EPPING PARK: STAGE 2 – BUILDING 6

ACCESS REVIEW

Morris-Goding Accessibility Consulting

20th June 2011

1 PARKING LEVEL 3
1 : 100

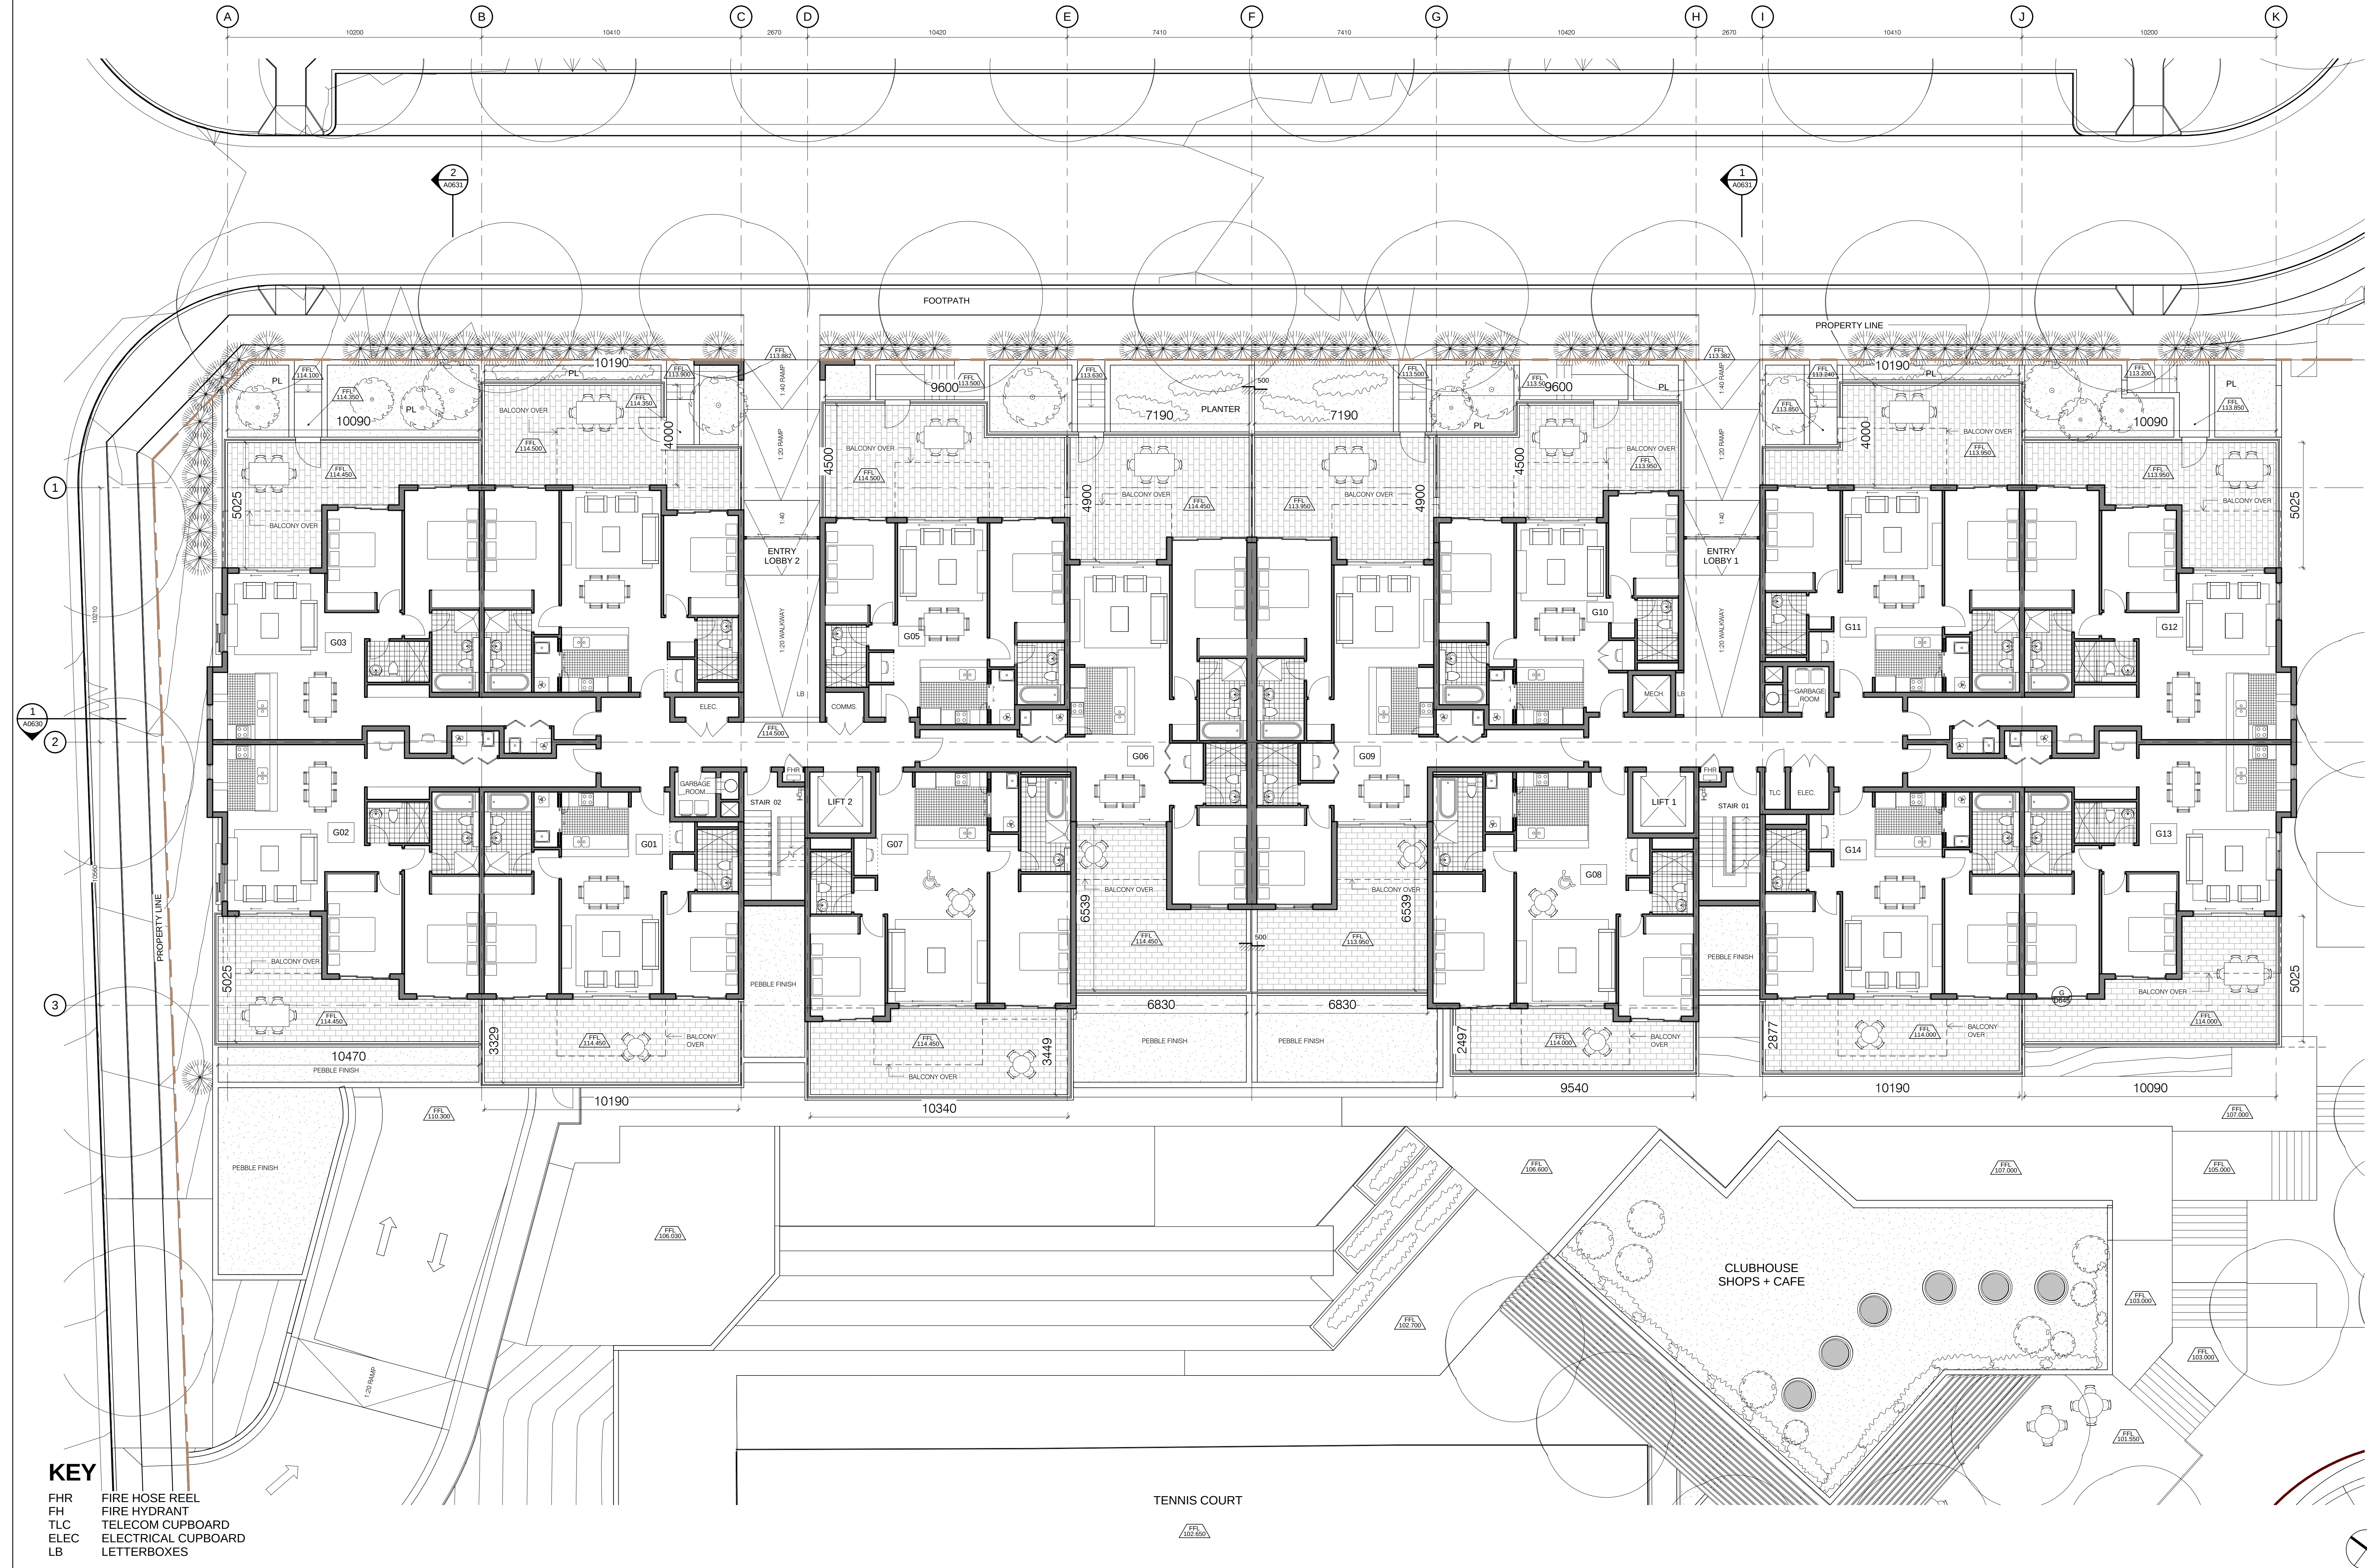
- (i) Ensure lift controls on Parking Level 1, 2 and 3 are located 900-1100mm from FFL and no less than 500mm from an internal corner in accordance with AS1428.1:2009, clause 14.1.
- (ii) Lift car components (grabrail, control buttons, lighting) to comply with AS1735.12.

1 PARKING LEVEL 1
1:100

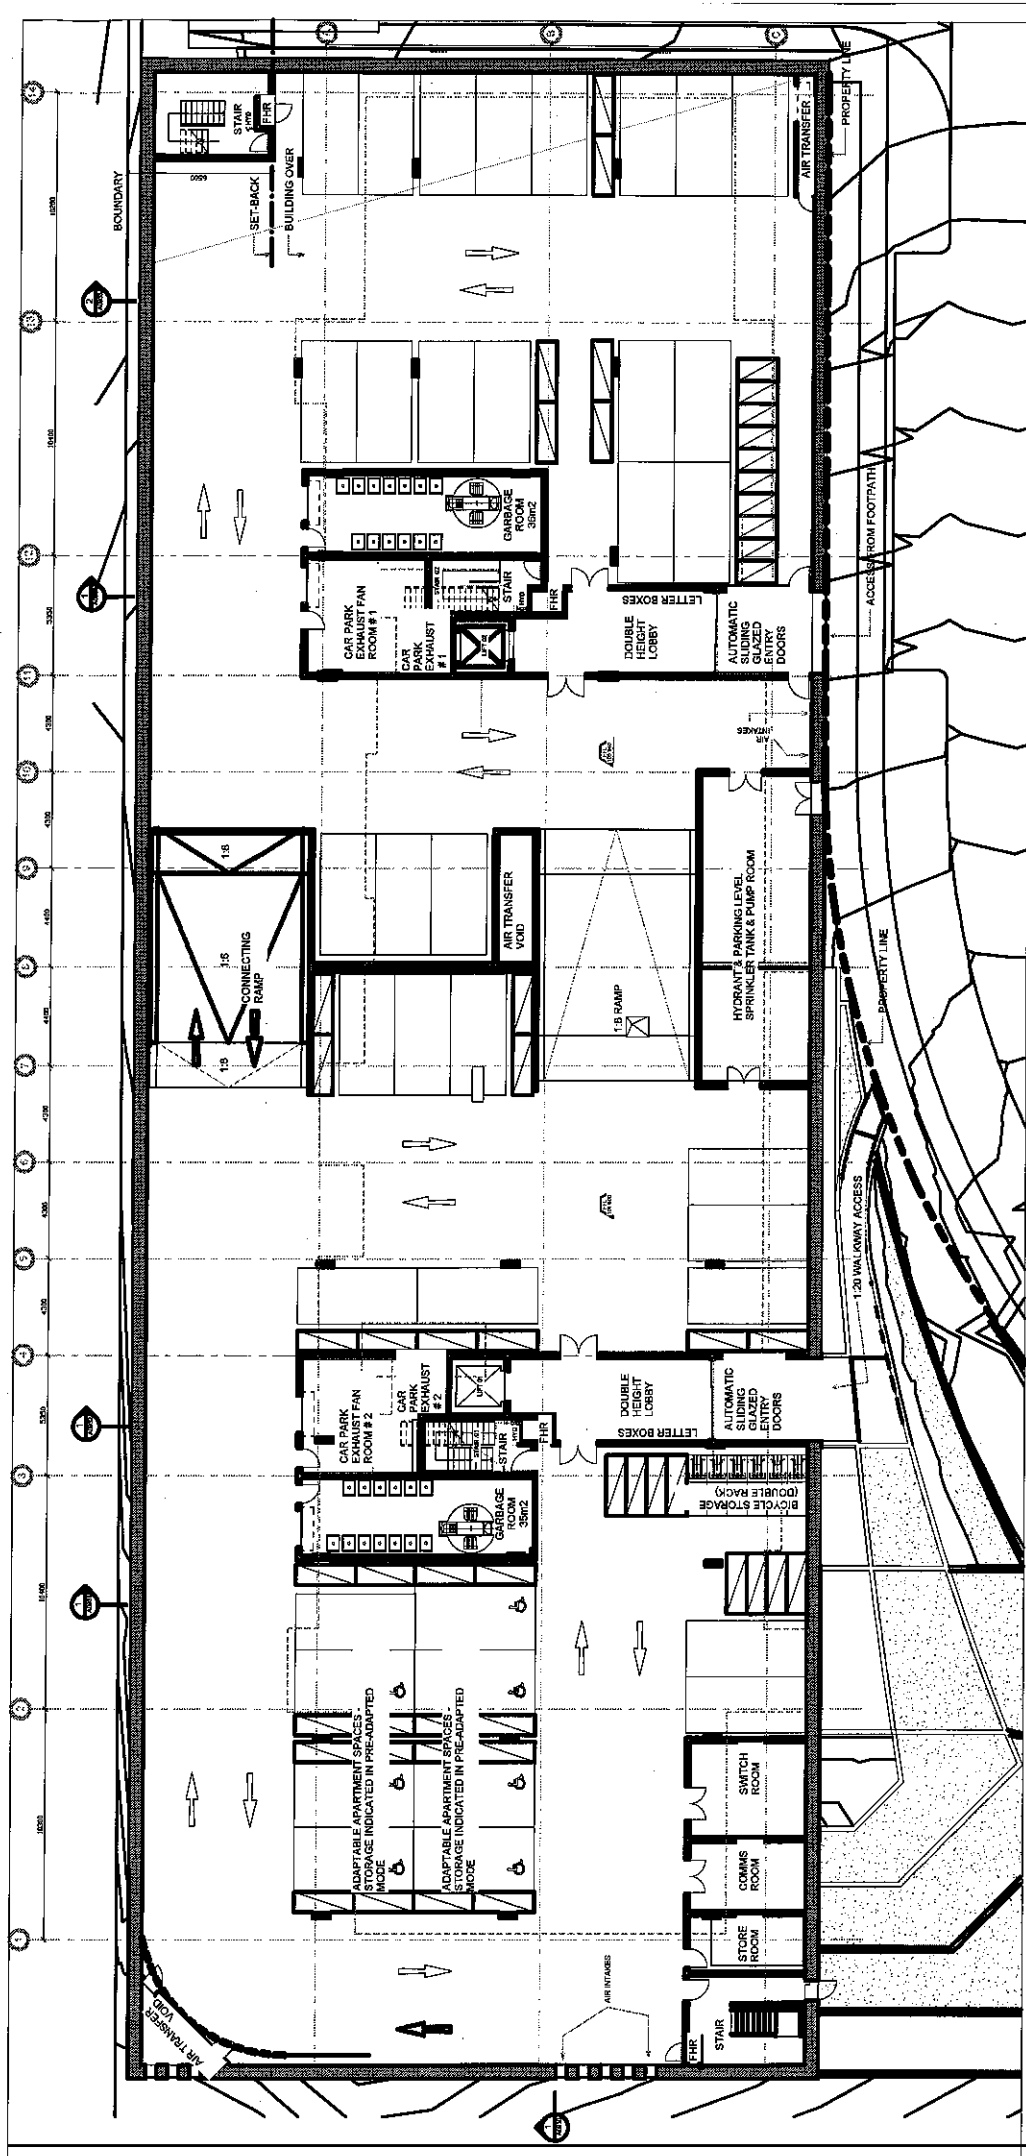
There is a Gymnasium and Pool located on Parking Level 1 which is accessible via the residential passenger lifts compliant with AS1428.1:2009, clause 6.1. From Lift 2, entry to the gymnasium and pool area is via the lobby doors which have an 800mm clear width. An 850mm clear width entry door is achievable.

There is an alternative path of travel from the central courtyard west of Building 6. There are stairs which provide access to the pool lobby. There is currently no accessible path of travel to the entry doors which has an appropriate 1100mm clear width in accordance with AS1428.1:2009 clause 13.2.

There is an accessible toilet and shower located on Parking Level 1, opposite the Sauna. The corridor entry has a clear width of 950mm which is inappropriate for a side approach.

The entry door has a 900mm clear width compliant with AS1428.1:2009, clause 13.2. The accessible WC has a 2.5m x 2.8m internal clearance which will be suitable for an AS1428.1:2009 compliant layout. Currently, the accessible pan circulation is encroached by the basin by 200mm non-compliant with AS1428.1:2009.

The lobby entry doors on parking level 1 have an 800mm clear width. An AS1428.1:2009 compliant doorway is achievable.

- (i) Ensure all residential lift lobby doors have a minimum 850mm clear width (920mm door leaf) in accordance with AS1428.1:2009.
- (ii) Provide an accessible path of travel from the central courtyard to the Pool Lobby compliant with AS1428.1:2009.

- (i) Ensure the accessible WC corridor has a 1240mm clear width path of travel suitable for a wheelchair side approach into the unisex WC.
- (ii) The layout of the pan needs to be rotated to the adjacent wall to ensure a clear circulation of 1900mm x 2300mm suitable for wheelchair access. The shower recess shall be located adjacent the pan with the basin opposite the toilet pan compliant with AS1428.1:2009.

- (i) Car bays require a width of 3800mm clear width compliant with AS4299.
- (ii) Parking level 1 requires an 850mm clear width compliant with AS1428.1:2009.
- (iii) All accessible car bays require a height clearance of 2.5 metres and 2.2m vertical clearance upon approach to each car bay.
